Your Ref :
Our Ref : P/91/17/NMA

Application for a non- material amendment following the grant of P/125/14/PL relating to approved plans.

251 Pagham Road, Pagham, ,

FOR
CRAYFERN HOMES LIMITED
Scale : 1:100 @ A1 Date : AUG 17
Drawing No : 108_16 SK04 Rev A

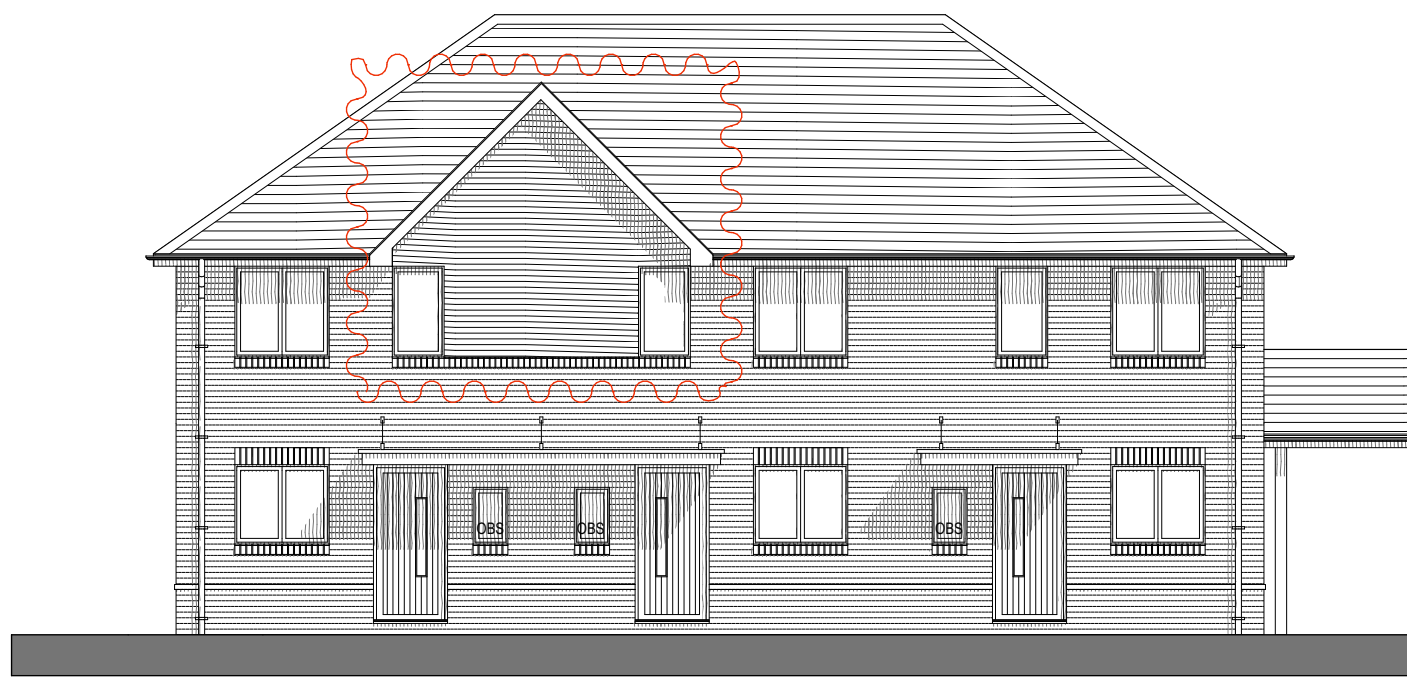
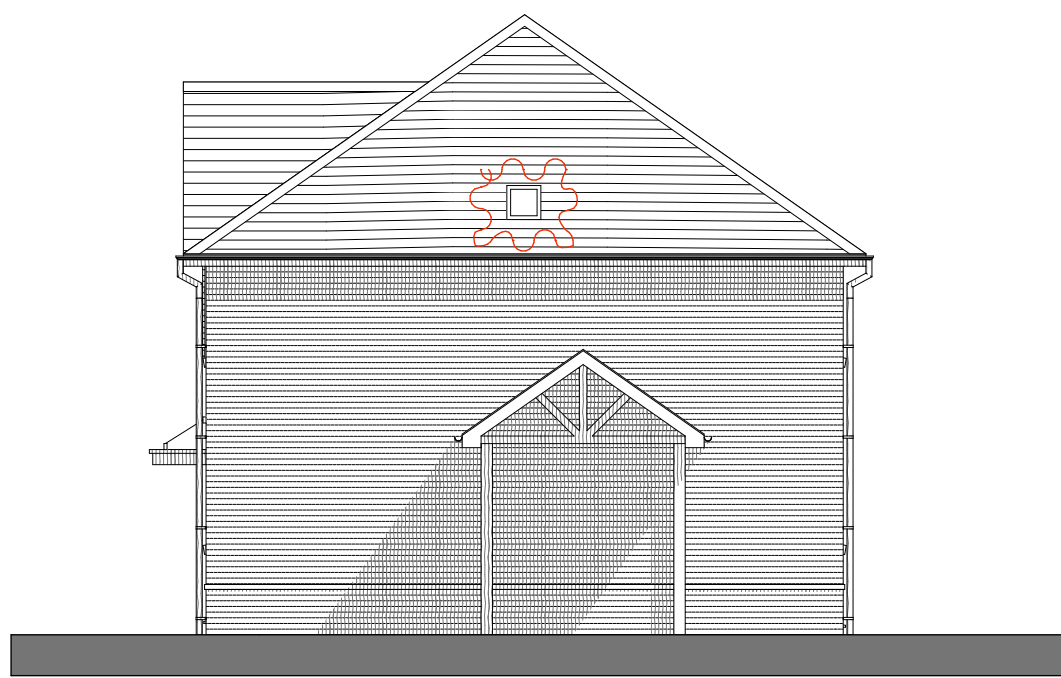
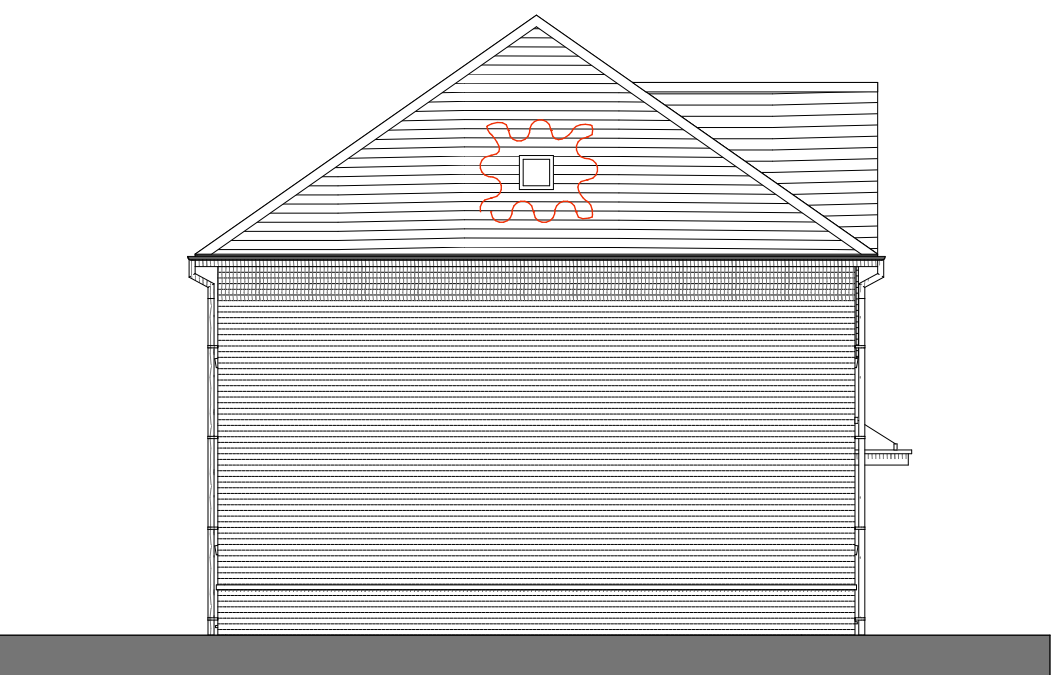
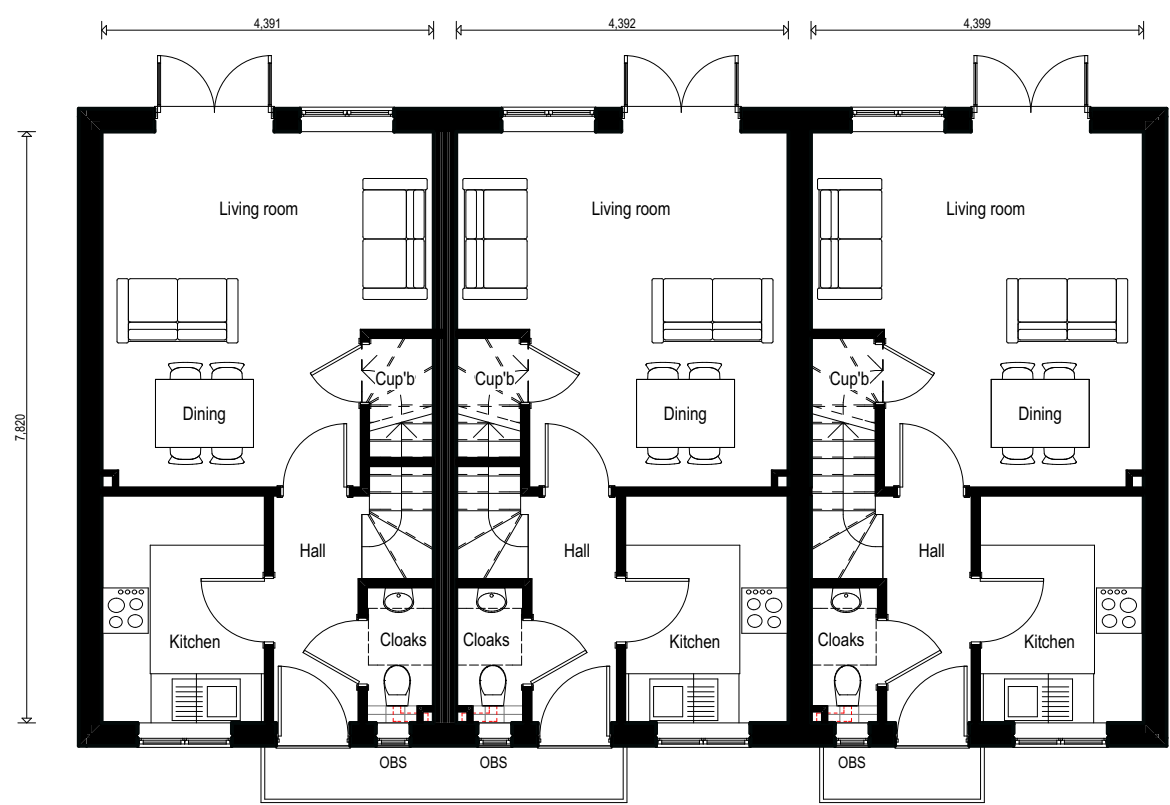
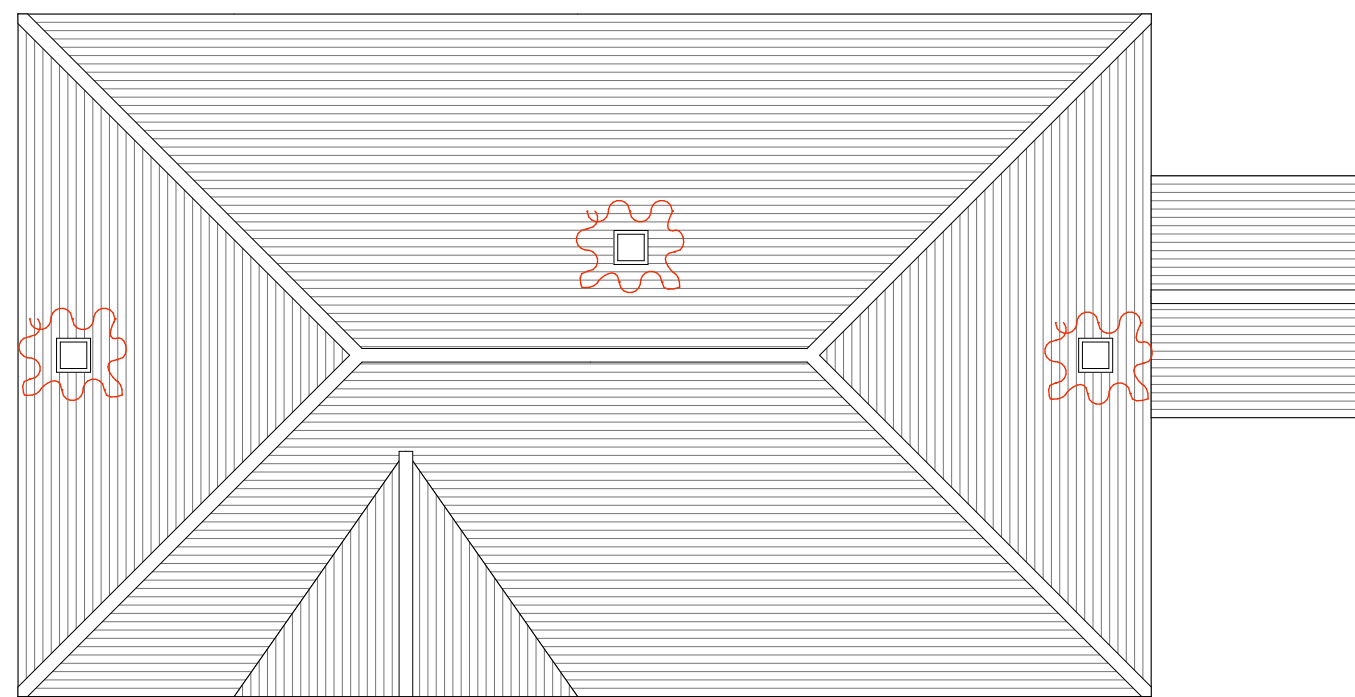
Plots 7-9 - Alteration to the materials/design of the front gable roof projection and addition of three sun tubes to the roof;
